From: Huw James [REDACTED]
Sent: 04 July 2019 09:06
To: Daun Johnson <Daun.Johnson@arun.gov.uk>
Cc: Lizzie Withall [REDACTED]
Subject: RE: Further Information Required on Your Ref: PP-07929008 Our Ref: FG/74/19/PL

Drawing Title
Proposed Elevations 1

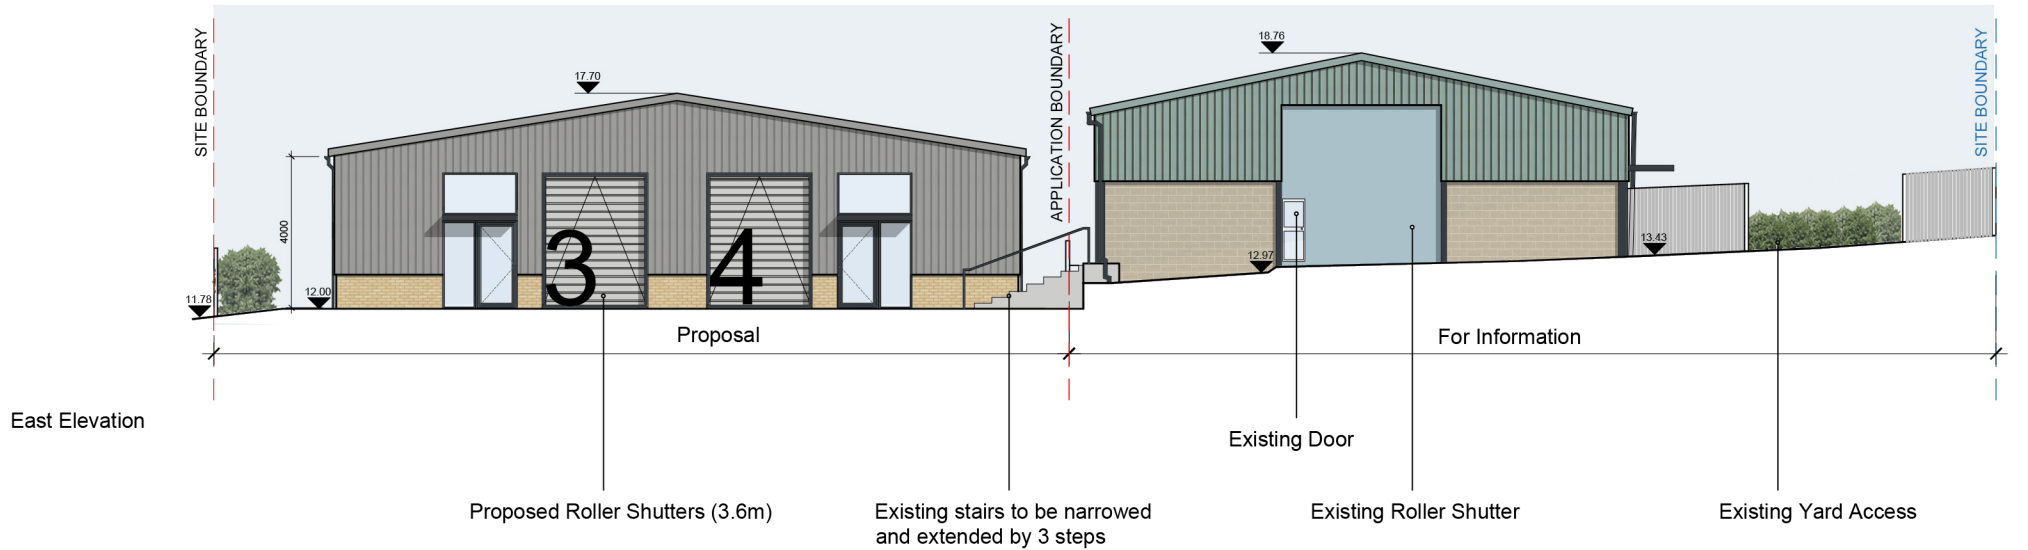
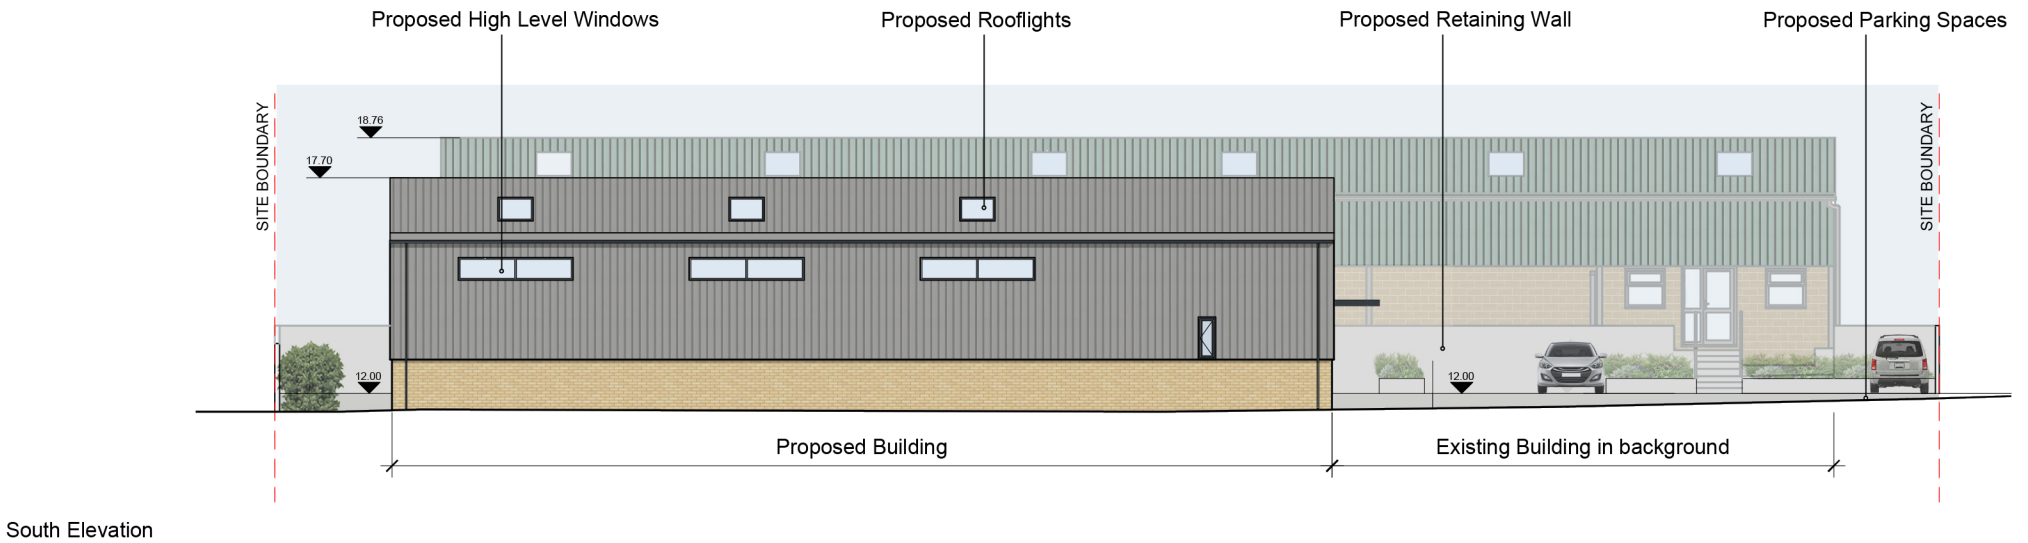
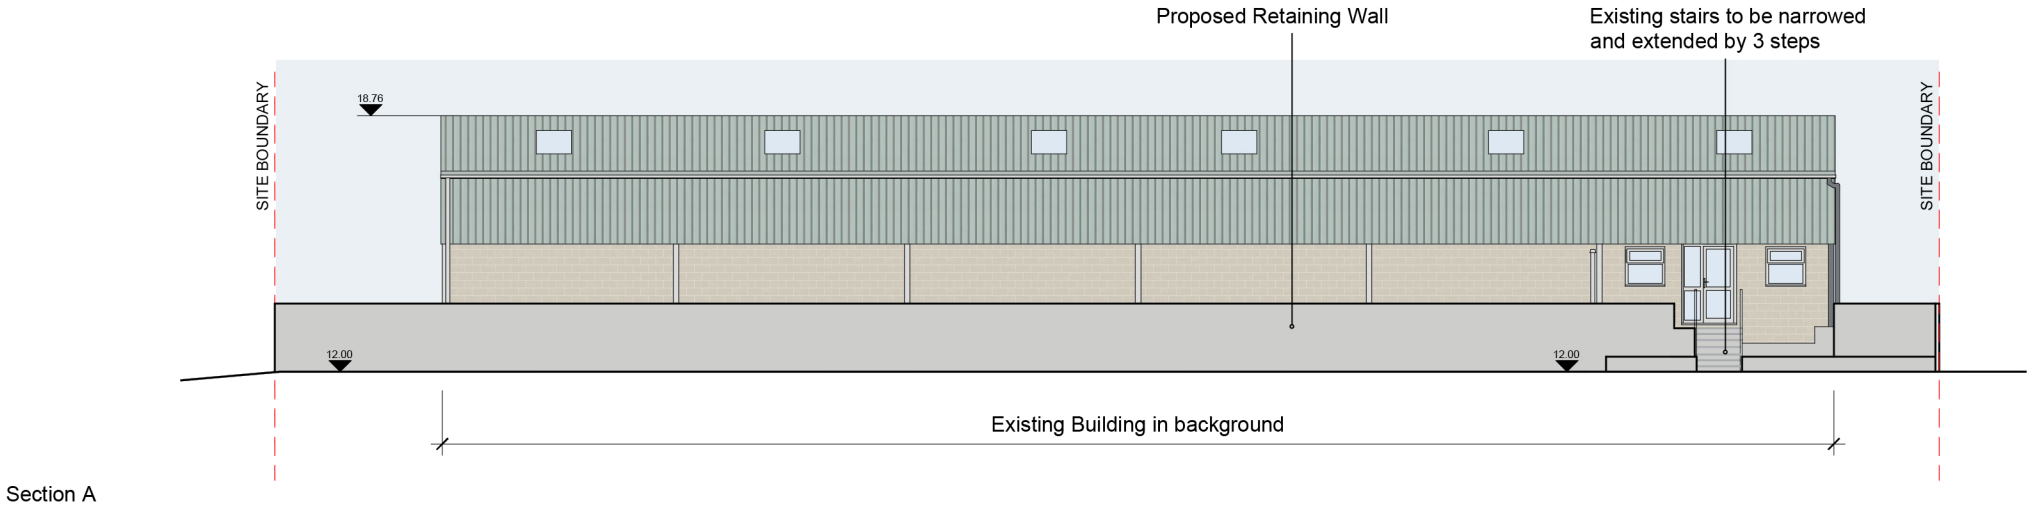
The East elevation is clearly shown at the top of drawing 3A.

The proposed building is also clearly shown next to the adjacent building on drawing 2A – there is no immediate building to the south of it as an access drive exists and the drawing shows the proposal clearly in situ alongside existing development. The proposal is also within a private industrial estate – not the public realm.

Section B (PROPOSED NORTH ELEVATION)

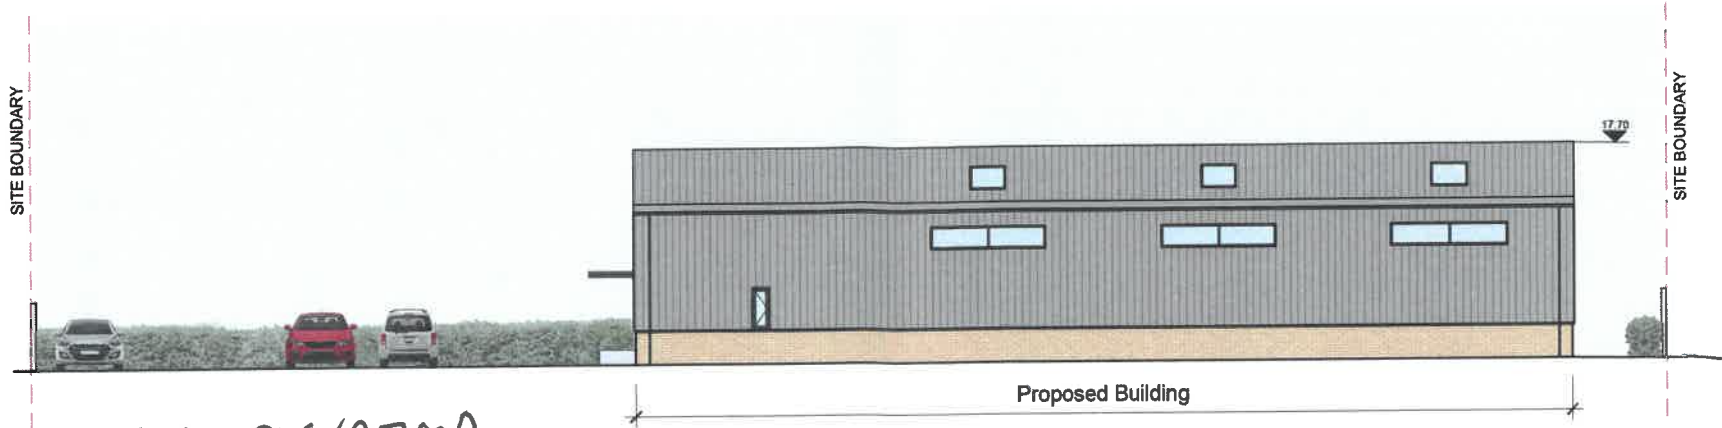
I can assume that Section B is the proposed North elevation.

For clarity, if you agree, I can label Section B as the proposed north elevation to include your annotation of Section B.

Yes please label Section B as north elevation as suggested.
